From: Martyn White <Martyn.White@arun.gov.uk>
Sent: 25 May 2021 19:08
To: Planning.Responses <Planning.Responses@arun.gov.uk>
Subject: CM/16/21/PL

CM/16/21/PL

Bairds Farm Shop, Garden Centre Crookthorn Lane Climping BN17 5SN

Convert existing on site storage to picnic area with fast food Cafe.

Block Plan
Scale: 1:500

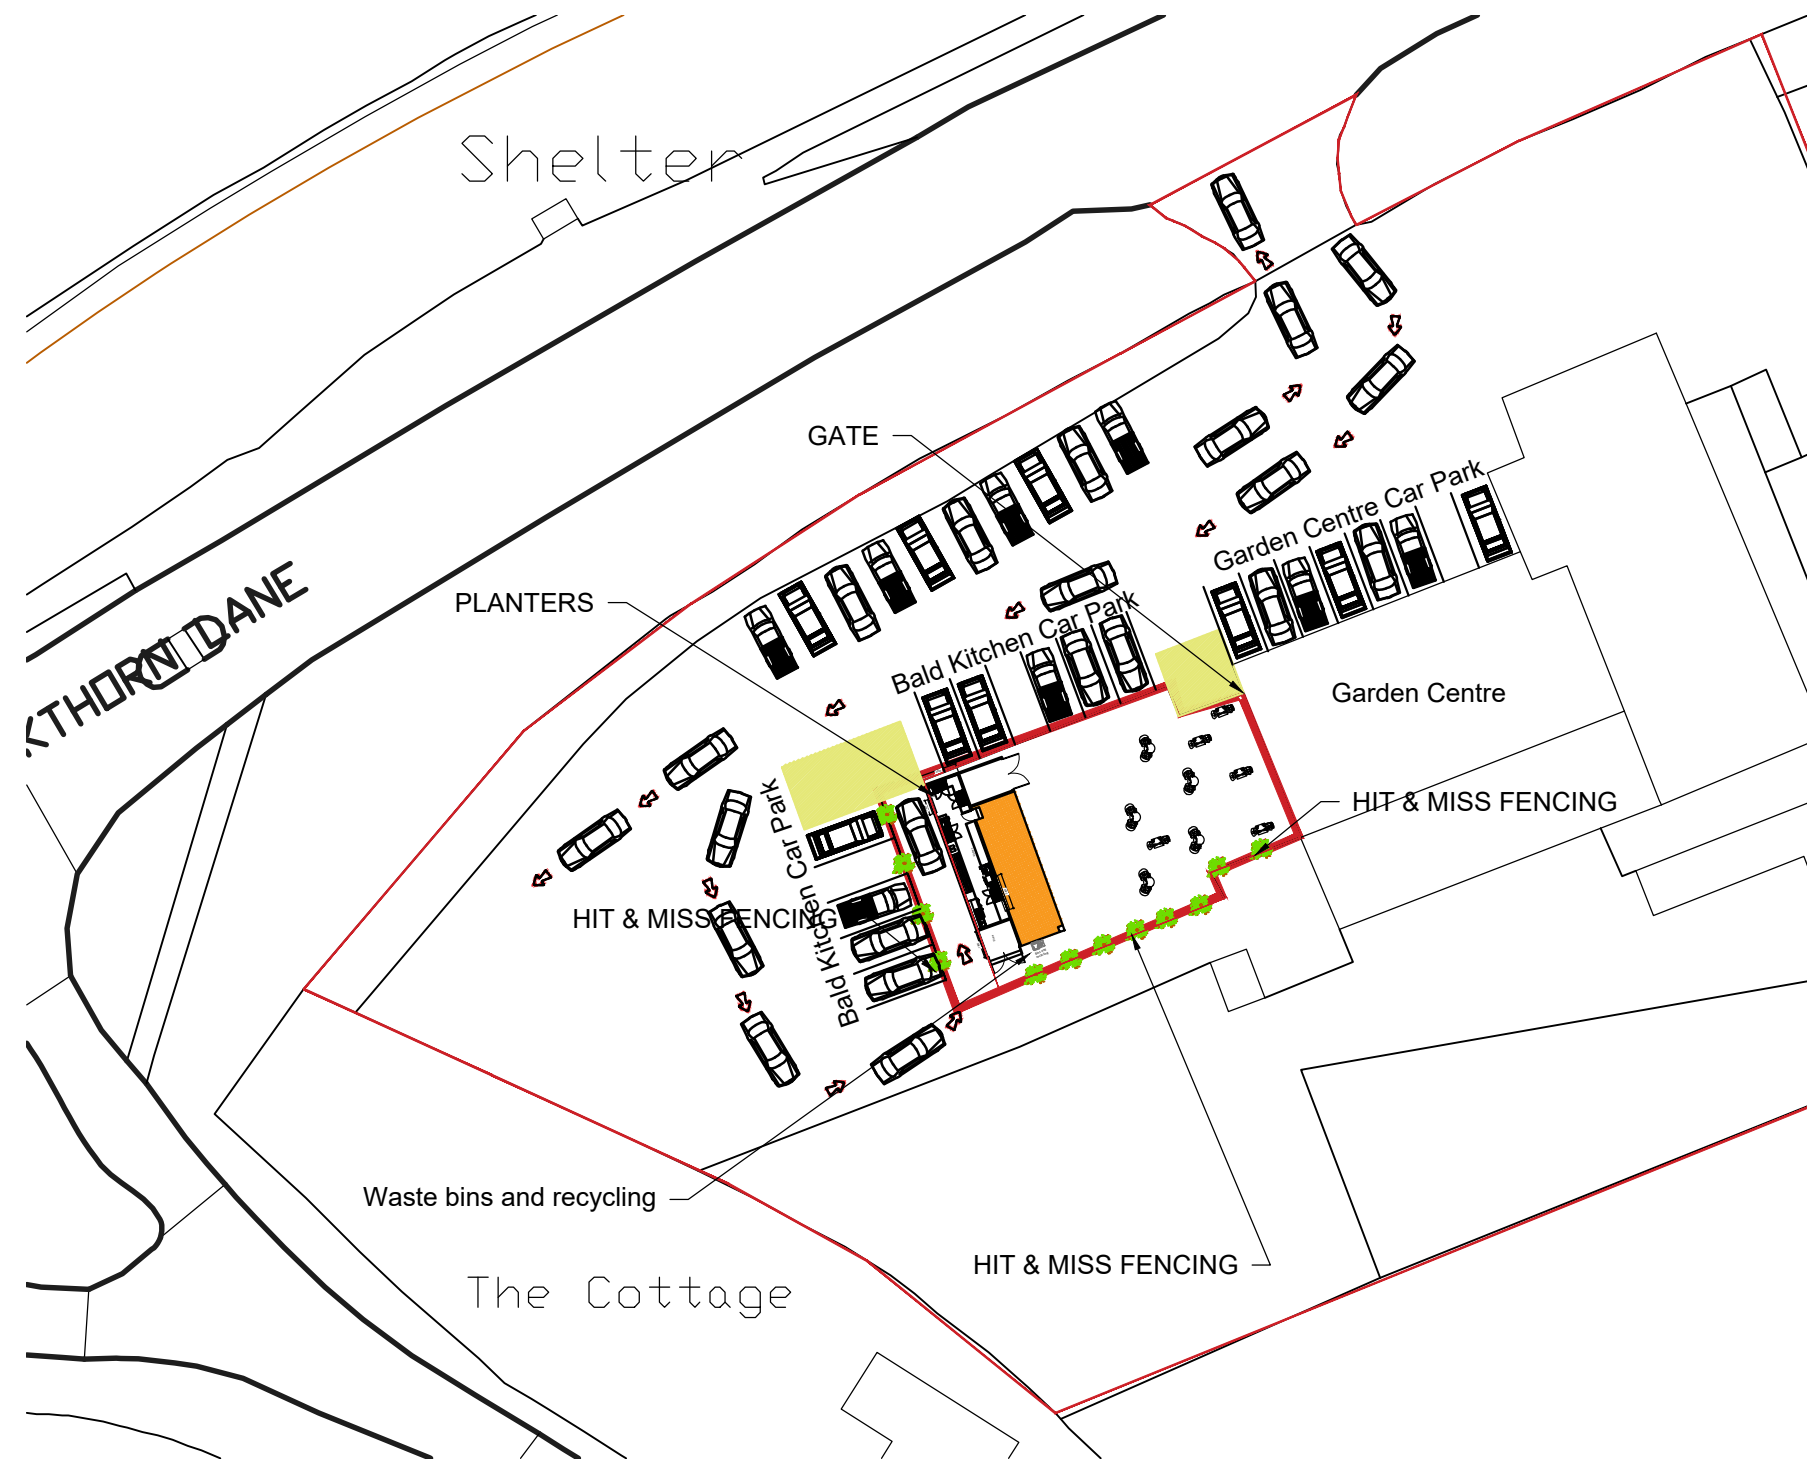
I am of the opinion that the proposal could cause some harm to the setting of the neighbouring heritage asset. I note that the Design and access Statement identifies that the landscaping scheme is to be confirmed. I would state that it might help to request details of screen planting to the 'drive through', so as to ensure that the development beds into the surrounding vegetation.

It would also help to have some additional vegetative screening in the part of the car park closest to the listed building, so as to ensure that it would not be seen on the context of the proposed development. If this is provided then the development would not cause harm

Proposed Front Elevation
Scale: 1:50

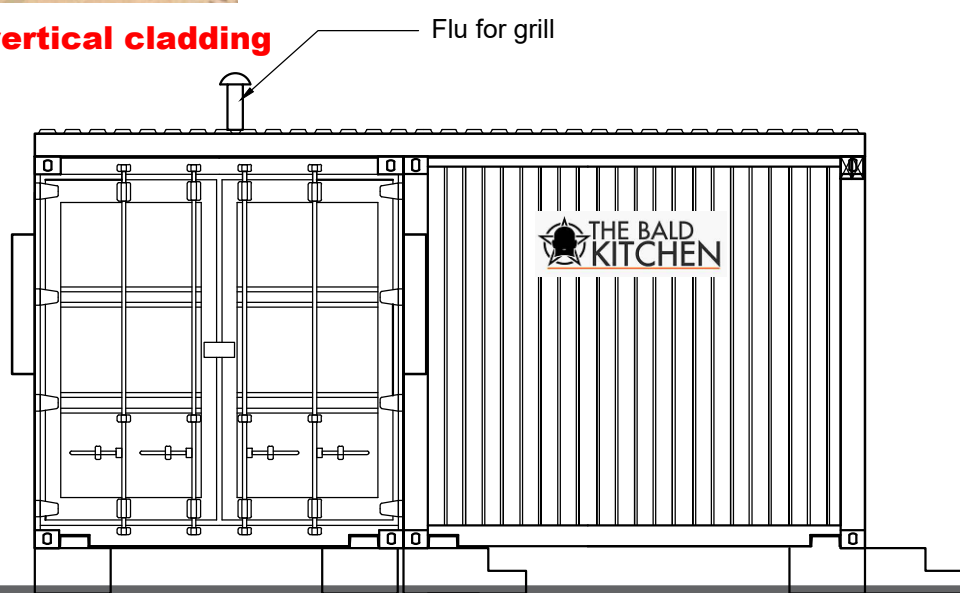
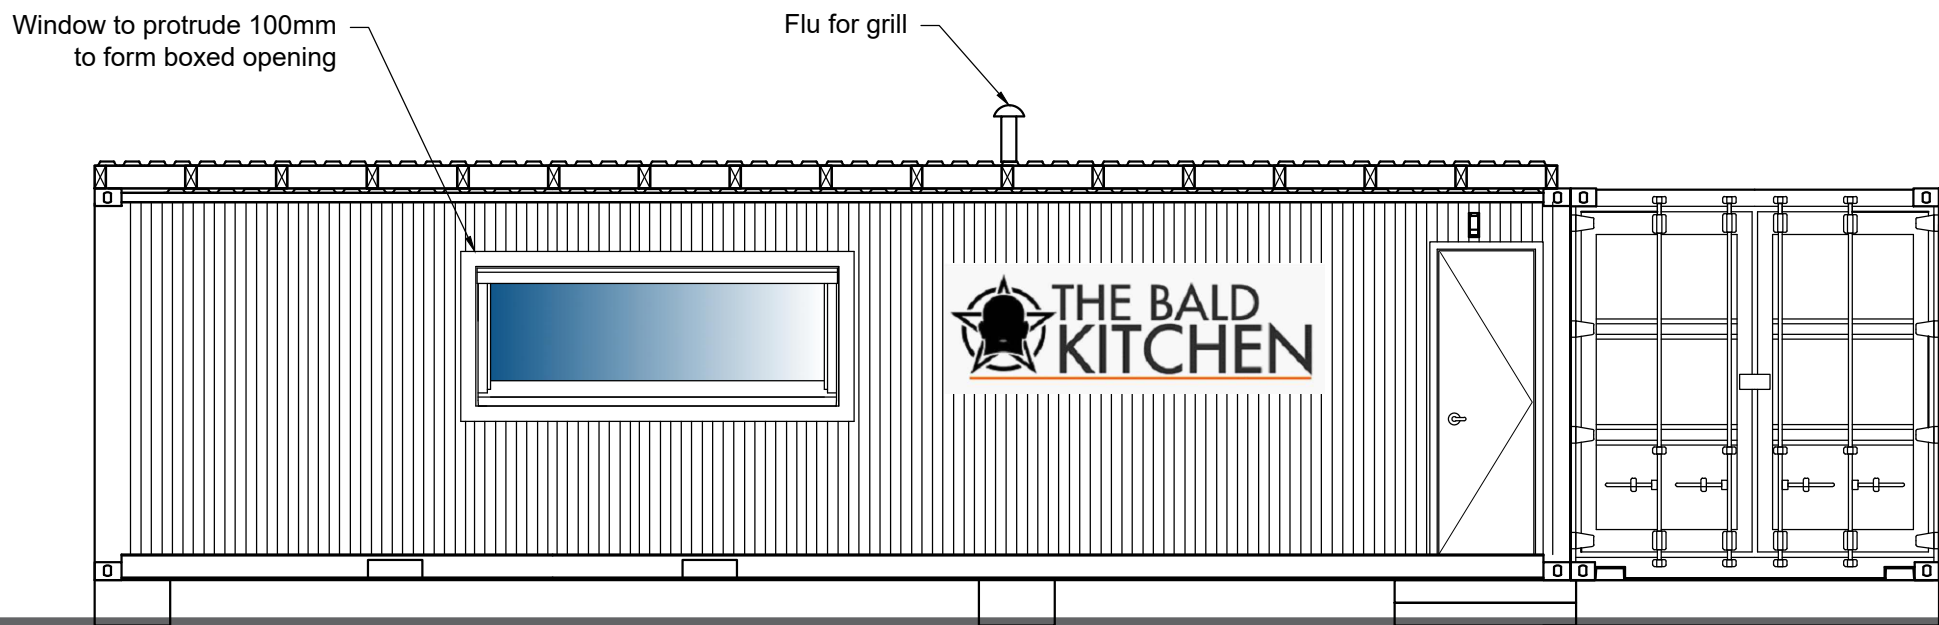
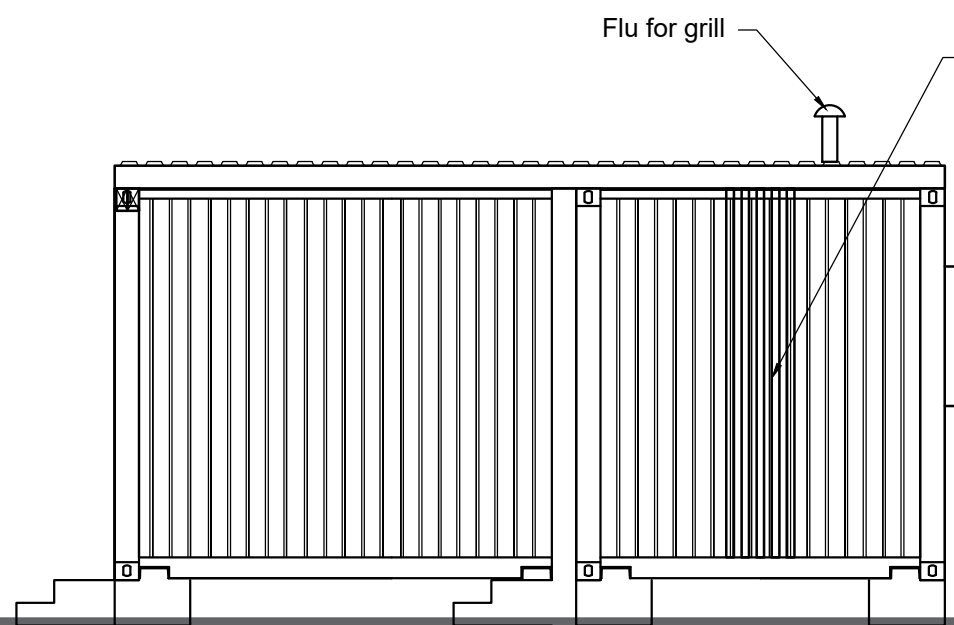
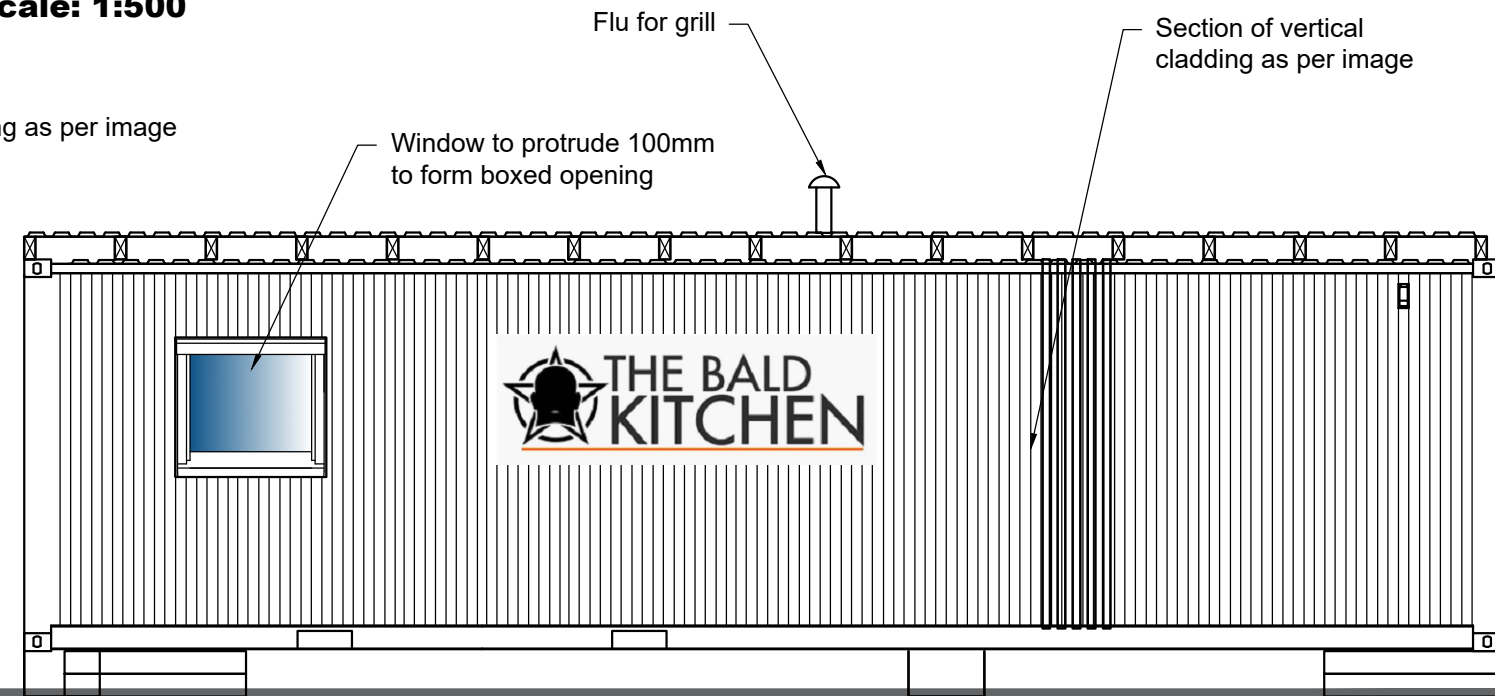
The proposed development would introduce a more urban character to the local area, which at present has a more semi-rural feel with a lack of visible development, tree presence and a limited number of residential properties located a short distance away in The Street. However, as the area has previously been used for retail uses, and part of it is currently used as an aquatic retail unit, the introduction of a café would result in the intensification of an existing site (including additional parking and noises etc). The use of shipping containers would ensure that they are more of a temporary nature and can be easily removed, leaving an empty site. The intention to clad them is more appropriate, and subject to their finishes could be acceptable.
